# Gatwick Airport Northern Runway Project

Appendix C: Response to Comments on the oCTMP at  
Deadline 4

Application Document Ref: 10.38

## 1 The Applicant's Response to Comments on the Outline Construction Traffic Management Plan

Appendix A: Gatwick NRP Temporary Compounds and Construction Vehicle (HGV) Access Routes

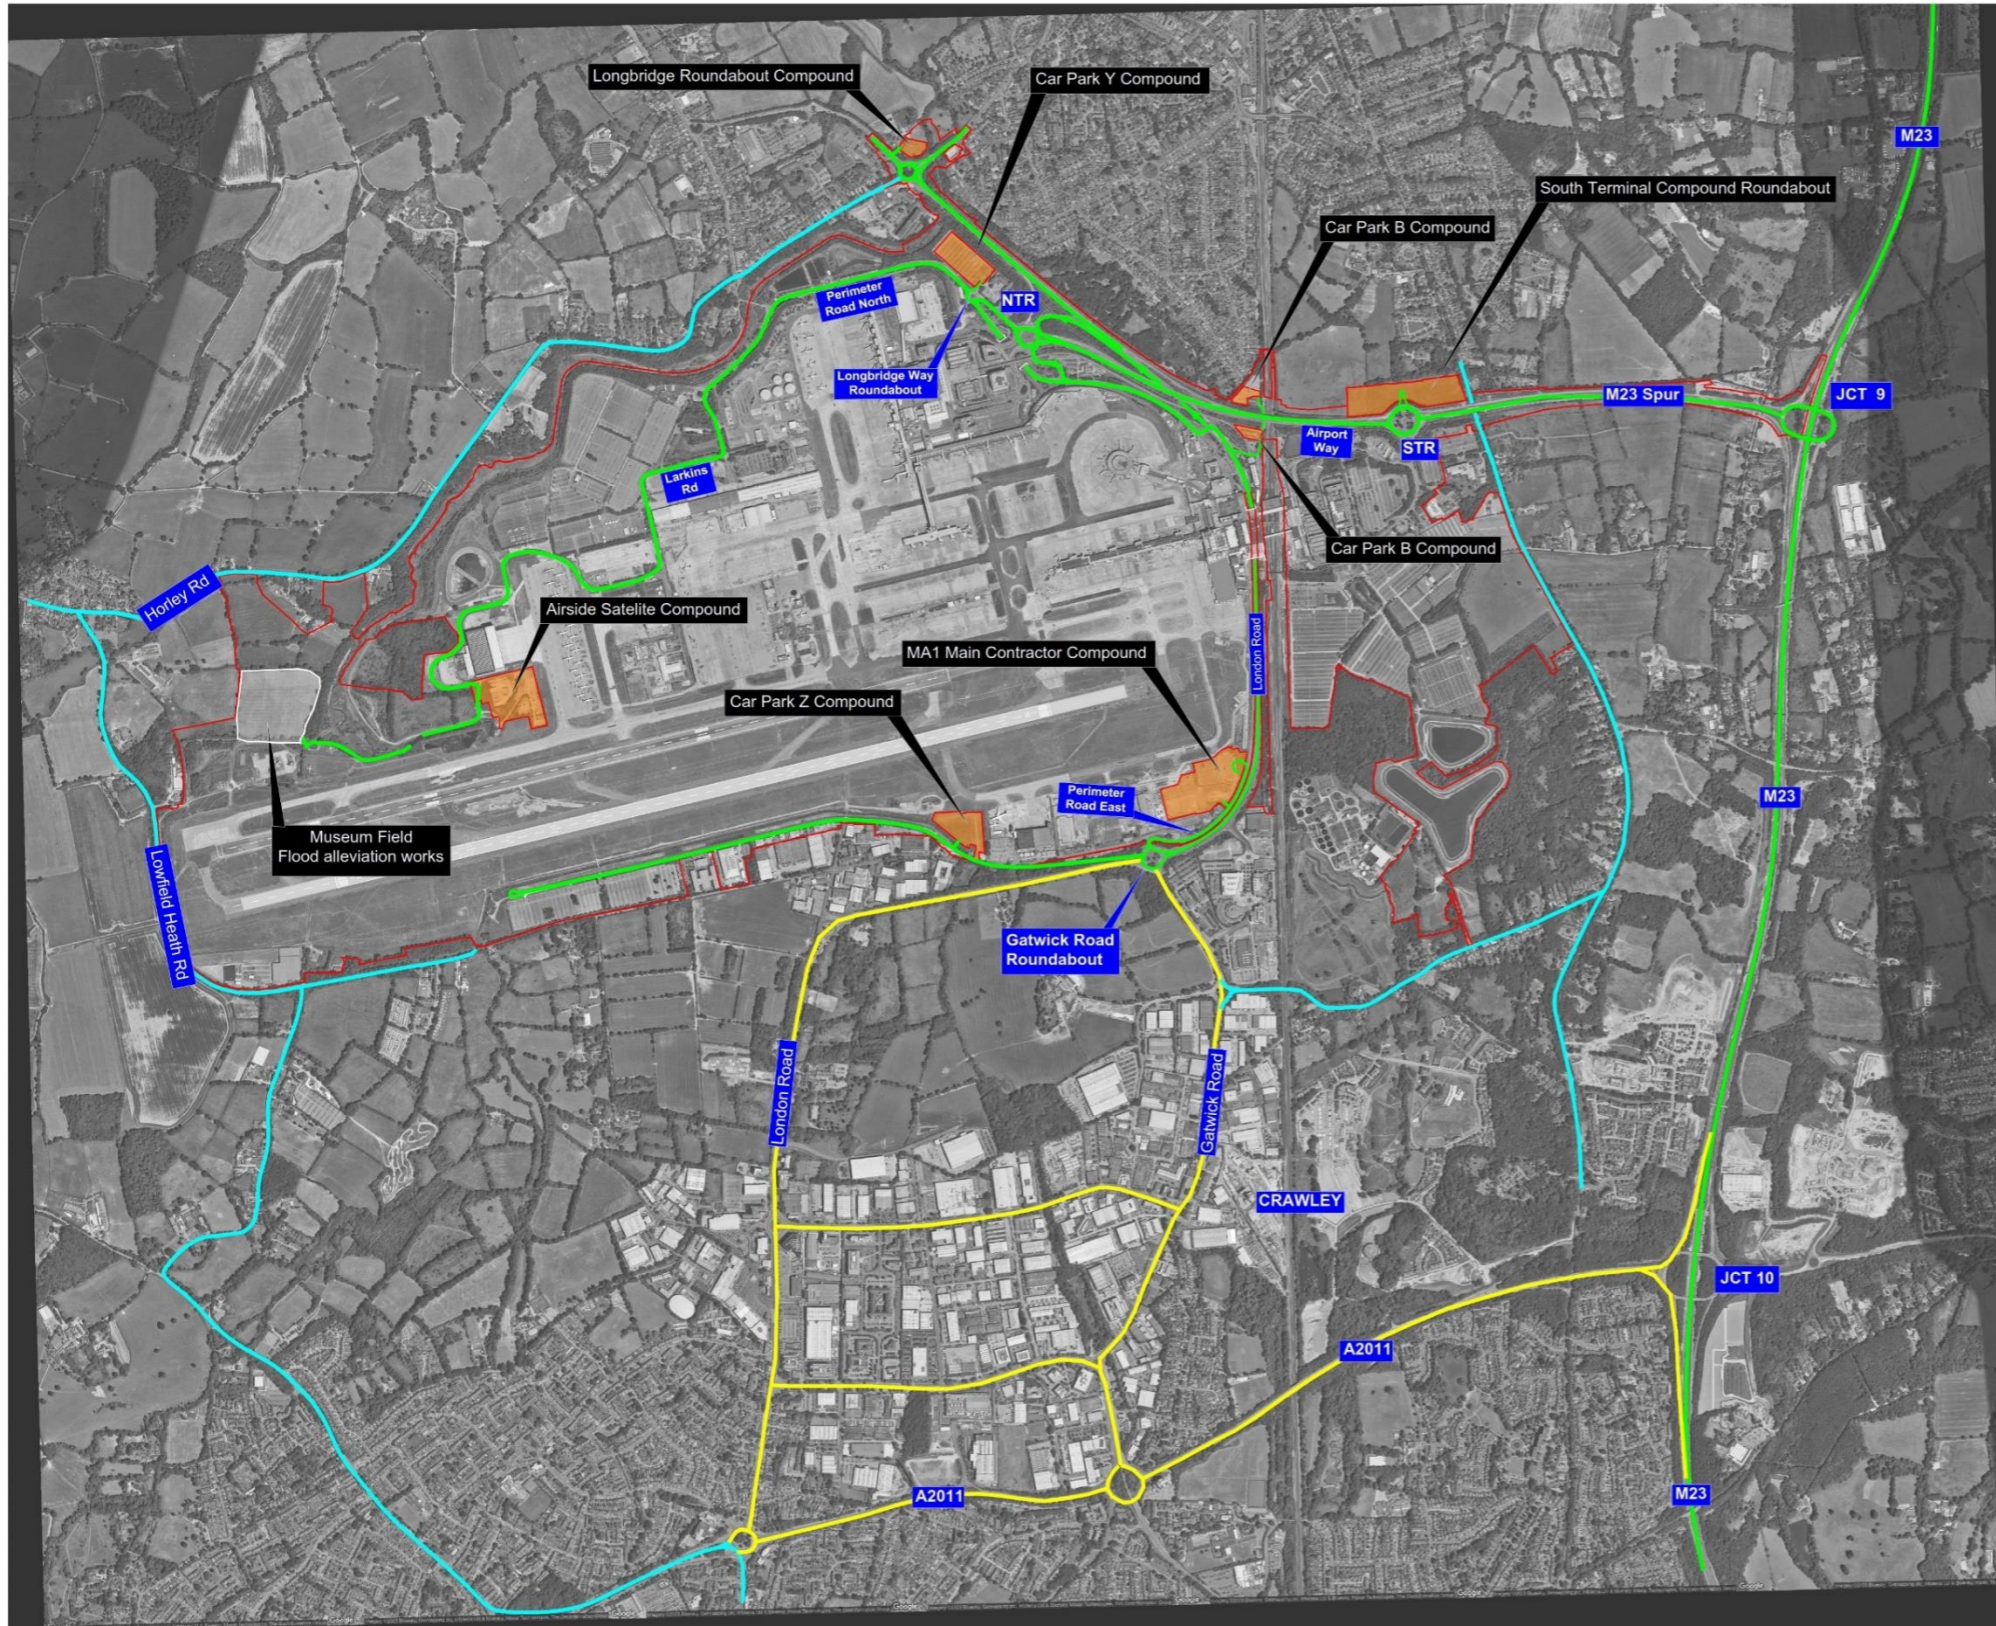
5.1.2 (BDBP7) National Highways	as per comment above	As explained in para 5.1.4 of the oCTMP, this is an outline document setting out the proposed construction vehicles routes and access to each construction compound. The final routes and access points will be detailed through the CTMP(s); to be subject to consultation and approval under DCO Requirement 12 and the authorised development must be constructed in accordance with the approved plan. On this basis, the additional text suggested by NH is not considered necessary, however, text has been added at paragraph 4.1.4 to clarify that the detailed CTMP(s) will adhere to the

principles and objectives of the OCTMP.
5.1.4 (BDBP8)  National Highways	as per comment above	<p>Amendments have been included to refer to managing construction traffic impacts associated with the Project in order to ensure the safe and efficient operation of the road network and minimise any negative environmental and community impacts, however it is not considered appropriate for this document to demonstrate that the construction compounds reduce traffic on the Strategic Road Network.</p> <p>The OCTMP will demonstrate the safe and efficient operation of existing roads, where applicable.</p> <p>During the consultation process on the CTMP, GAL will consider any proposals or suggestions put forward by CBC, WSCC, SCC and NH in line with DCO Requirement 12. If a change cannot be taken forward by GAL, sufficient justification will be provided to the relevant authority. It is not considered necessary to set out such a requirement within the oCTMP as this is standard good practice in discharging requirements and engaging with stakeholders, which GAL will follow. The extent and strength of wording put forward by NH is also not considered reasonable or necessary.</p> <p>On the basis of the above, no change required to the oCTMP text.</p>

CTMP which routes will be prohibited	
6.2.2 ( <b>BDBP19</b> ) National Highways	Tied to the above comments, not only must the oCTMP must ensure that there is sufficient certainty as to which routes will be prohibited for use, but also which routes will be approved for use via construction vehicles	The oCTMP has been updated to address NH's comment.
6.3 ( <b>BDBP20</b> ) National Highways	In appendix A the applicant sets out three categories of routes (Primary, Contingency and Restricted Use). The applicant should make commitments in respect of all three, not just two	Comment Accepted. The oCTMP has been updated to incorporate the amendment.
6.3.1 ( <b>BDBP21</b> ) National Highways	NH consider that the commitment to provide further information needs to include a commitment to consult the relevant planning	Comment Accepted. The oCTMP has been updated to incorporate the comment.

<p>relevant highway authority, and in this instance of signage proposal in the SRN brings this section in line with the agreed position in the PPs</p>	
<p>6.8 (<b>BDBP31</b>)  National Highways</p>	<p>As an overall comment this is the kind of detail we had expected to see from GALs oCTMP - there needs to be specific and prescriptive measures outlined in the oCTMP to provide certainty as to kinds of measures that will be taken to mitigate construction impacts on safety</p>	<p>Comment Accepted. The oCTMP has been updated to incorporate the comments</p>
<p>6.9.2 (<b>BDBP32</b>)  National Highways</p>	<p>The applicant has been aware of these works for some time. The lack of certainty provided here must be rectified given the modelled impacts are based on specific routes. Replacement routes must be</p>	<p>Comment Accepted. The oCTMP has been updated to address the comment by setting out replacement routes.</p>

set out - to avoid the traffic modelling being a chocolate teapot, security must be provided on the routes	
6.9.4 ( <b>BDBP33</b> )  National Highways	As per comments above	Comment Accepted. The oCTMP has been updated to reflect NH's requested text.
